KIRKLEES METROPOLITAN COUNCIL INVESTMENT & REGENERATION SERVICE

DELEGATED DECISION TO DETERMINE APPLICATIONS FOR LISTED BUILDING CONSENT

Reference No:	2020/65/94197/W
Site Address:	78, Wellhouse Green, Golcar, Huddersfield, HD7 4ET
Description:	Listed Building Consent for erection of single storey extension to side (within a Conservation Area)
Recommending Officer:	Sam Jackman

Officer Report – Listed Building - 2020/94197

Project		
Proposed side extension.		
For		
Mr & Mrs E Blackmore.		
Address		
78 Wellhouse Green Golcar HD7 4ET.		
Title		
Planning Drawing.		
Job No.	Drawing number	Date
20 J 41.	01 D.	Oct 2020.

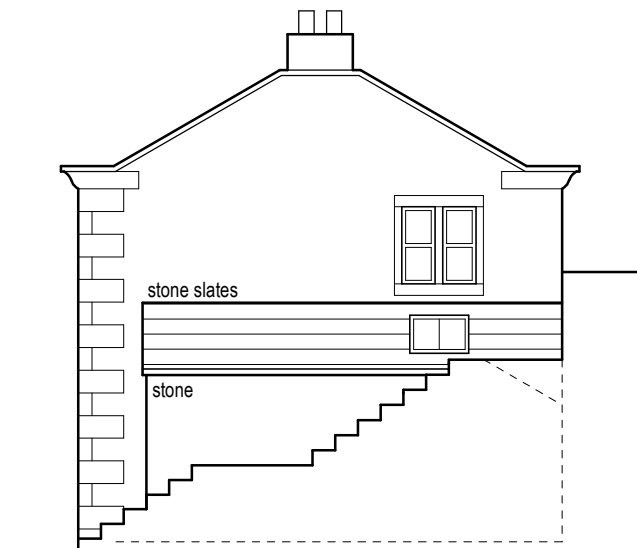
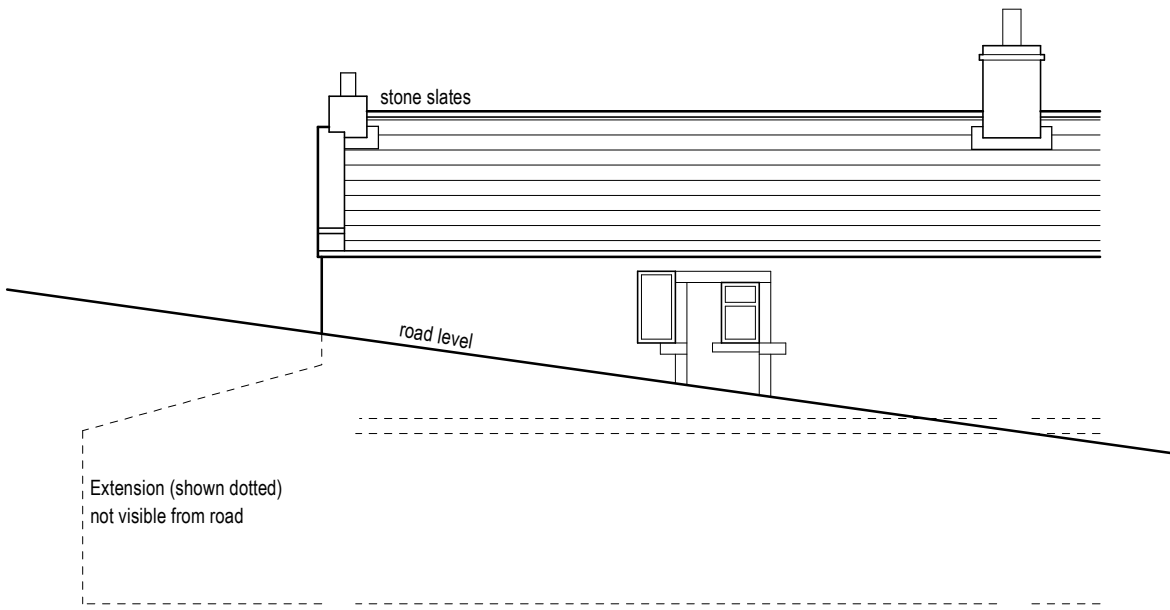
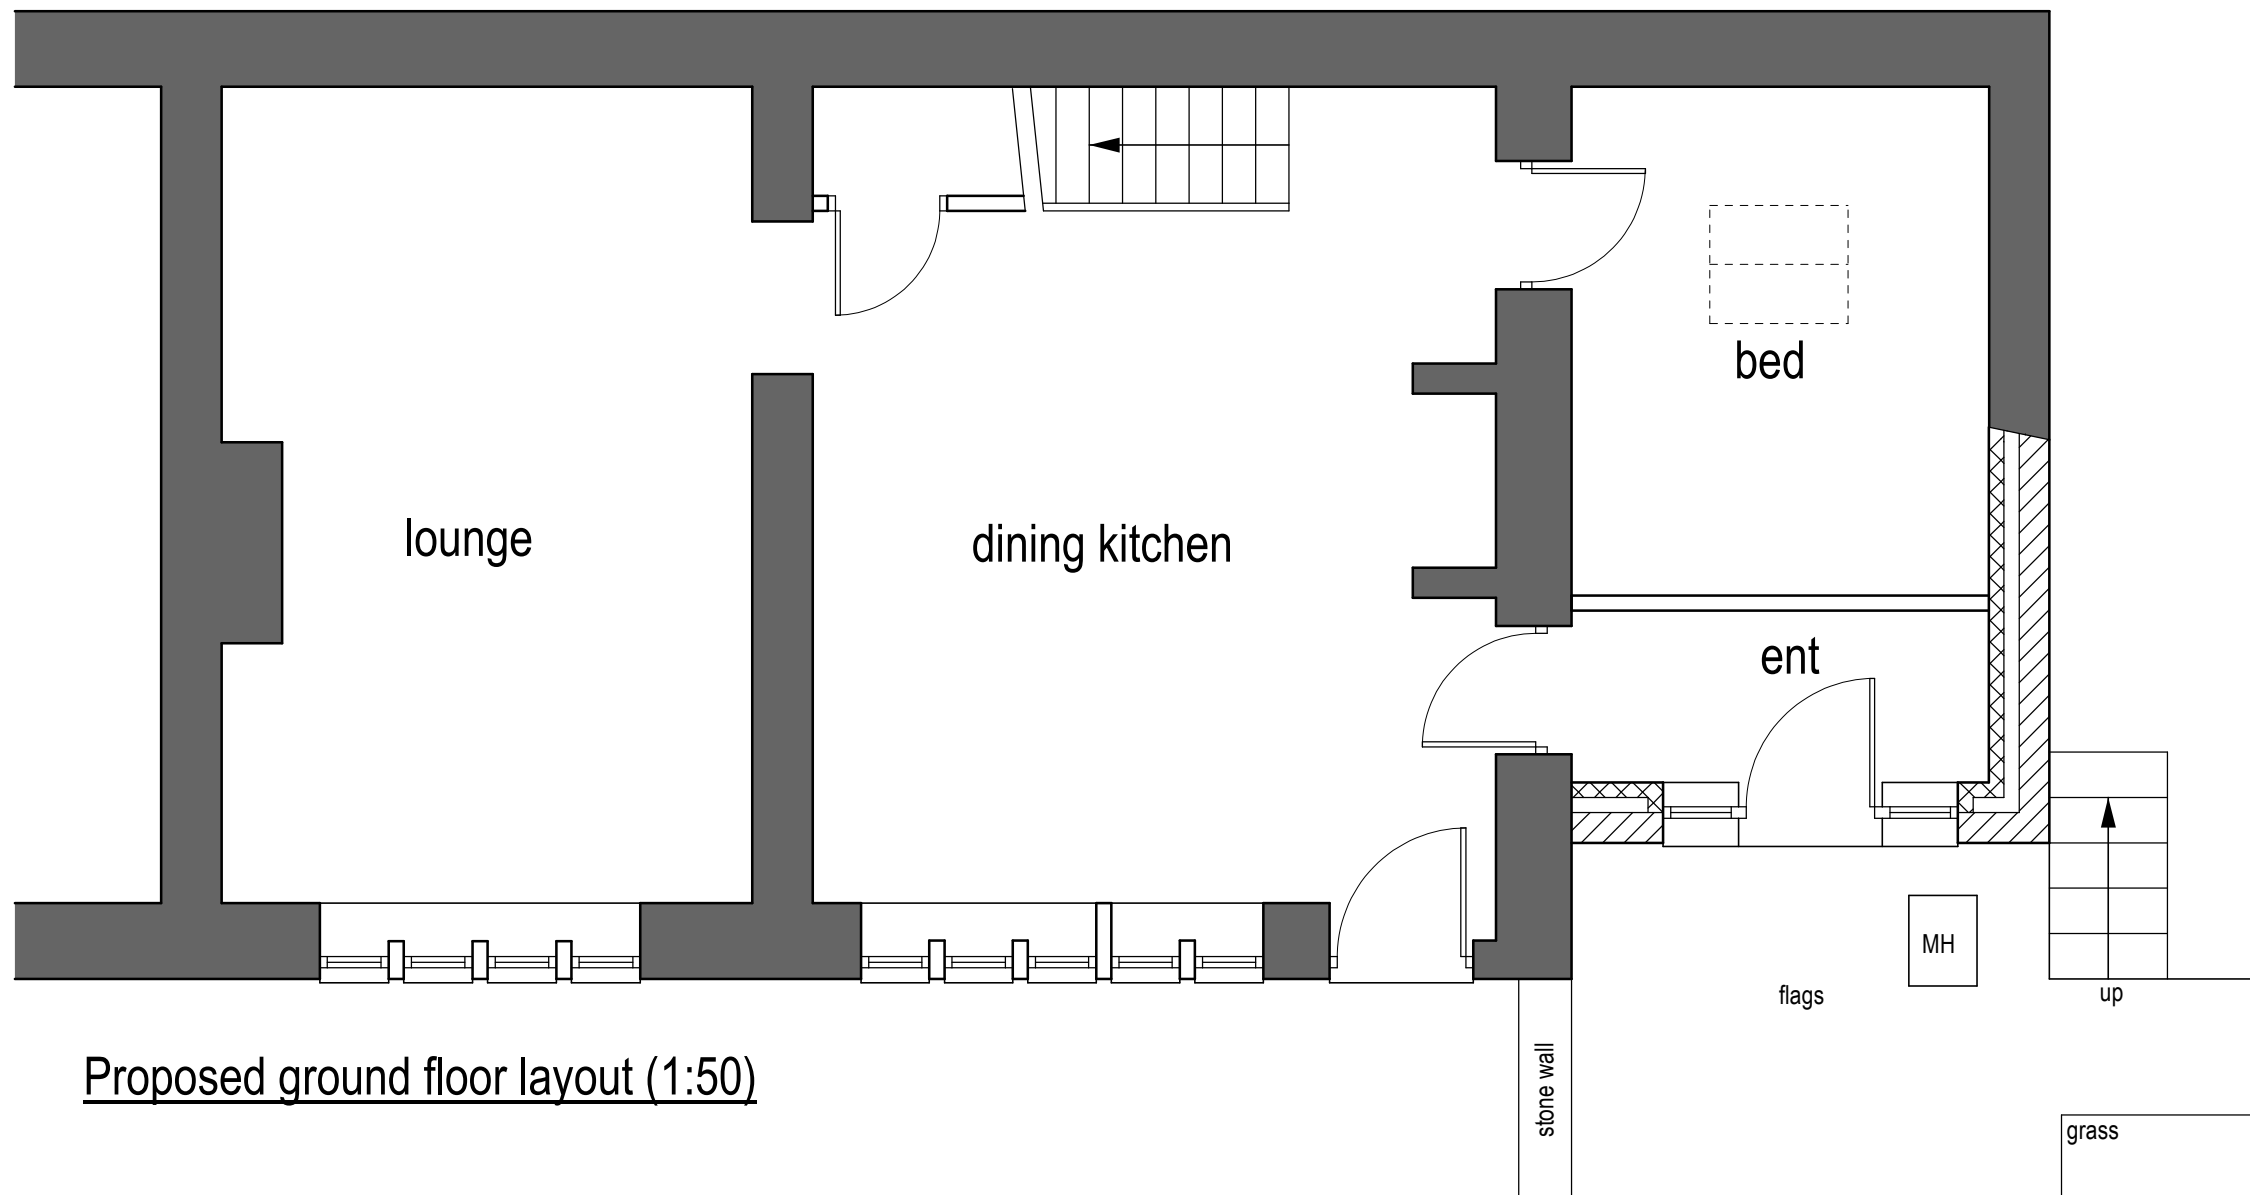
The application as amended is of a similar size to the 2009 application, however, the front elevation has been set back 0.9m to reveal the quoins, the fenestration details reflect the existing extension with a single window to the right of the entrance and with only 1 roof light. Materials proposed are natural stone with a stone slate roof.

The extension is considered to relate well to the host building and have an acceptable impact on visual amenity in general. It is now a modest proposal in a quality design that would provide an organic addition to the host dwelling and improve on the appearance of the existing smaller side extension. The detailing would ensure that the overall impact would be neutral to the significance of the listed building.
